Application: SSI 7485

I write regarding the proposed modification to M4-M5 Link, Mod 2 The Crescent overpass and changes to pedestrian infrastructure in North Annandale, Rozelle and Rozelle Bay Foreshore area. *I object to the overpass and to the relocation of the GreenLink and*

**Figure 4 | Proposed modification** (Source: Design Amendment Report)

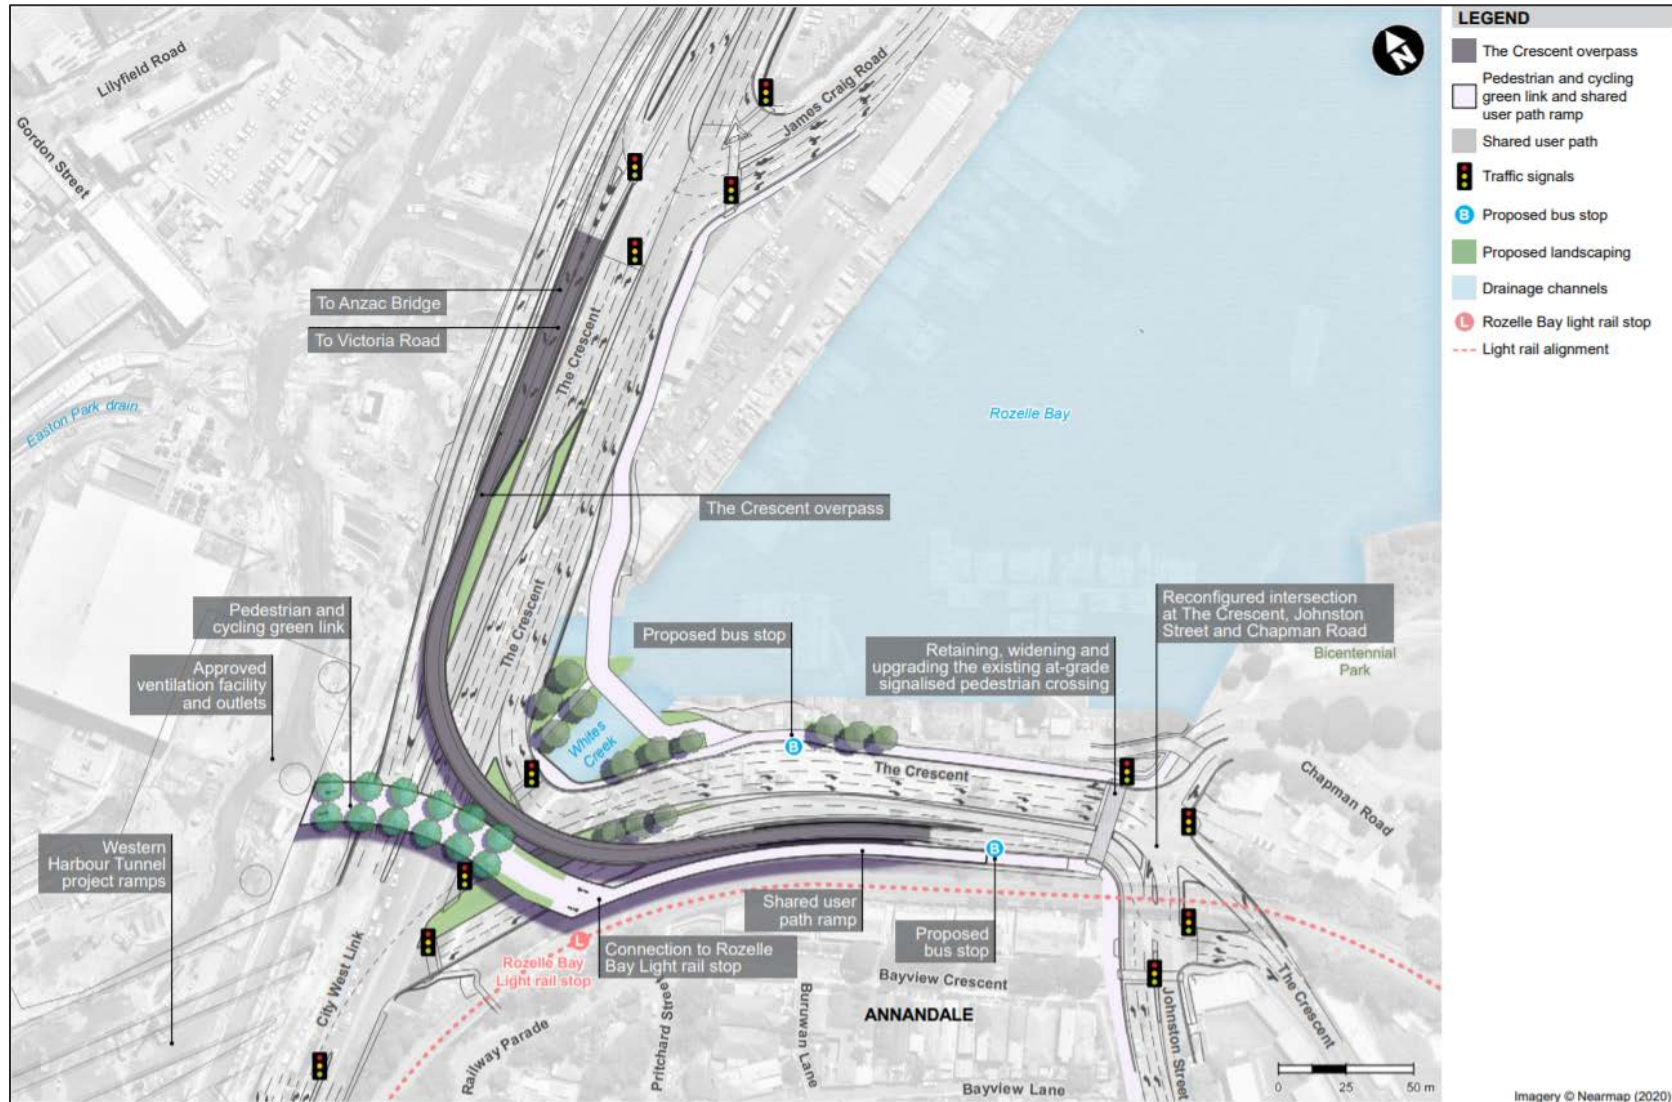
I request RMS work with the community to explore alternate design options to the proposed new car overpass design and the changed pedestrian and cyclist links. I am seeking the reinstatement of the safe, direct access from the approved EIS GreenLink to create a continuous green open space connection from the Rozelle Rail yards and Annandale to the foreshore. The GreenLink was more than just a walk way - it put people central to the design, maximising safety, and providing much needed accessible open space for the community now and into the future Bays Precinct design.

- The significantly reduced safety and increased risk for pedestrians and cyclists with removed access over The Crescent to Bicentennial Park and the increased traffic along Johnson Street.
- Being required to cross five sets of pedestrian lights at The Crescent as my option to reach the foreshore from Annandale or from Rozelle Bay light rail stop.
- Removal of direct active links to the foreshore, cutting the community off from the area and the proposed revitalisation of the entire Bays Precinct, including linking the Light Rail and Bus stops to a Ferry wharf and Metro station.
- Urban and landscape design that is being built before a finalised Masterplan for the area.
- Traffic changes that limit movements around the suburb and create further congestion in the local streets of Annandale, Forest Lodge, Glebe, Lilyfield and Rozelle with no planning to deal with these.

- Reinstate the GreenLink connecting communities and green open space from Rozelle to Bicentennial Park
- Relocate and design pedestrian and cyclist connections that are continuous, safe and direct.
- Design the modification infrastructure and active links in response to the character of the suburbs, the location of the foreshore and it's potential future development.
- Provide pedestrian and cyclist paths that maximise people safety and do not force them onto busier streets, unsafe concrete plazas and caged walkways.
- Integrate active and direct connections to all active transport – including the future Metro West and Foreshore Ferry Wharf
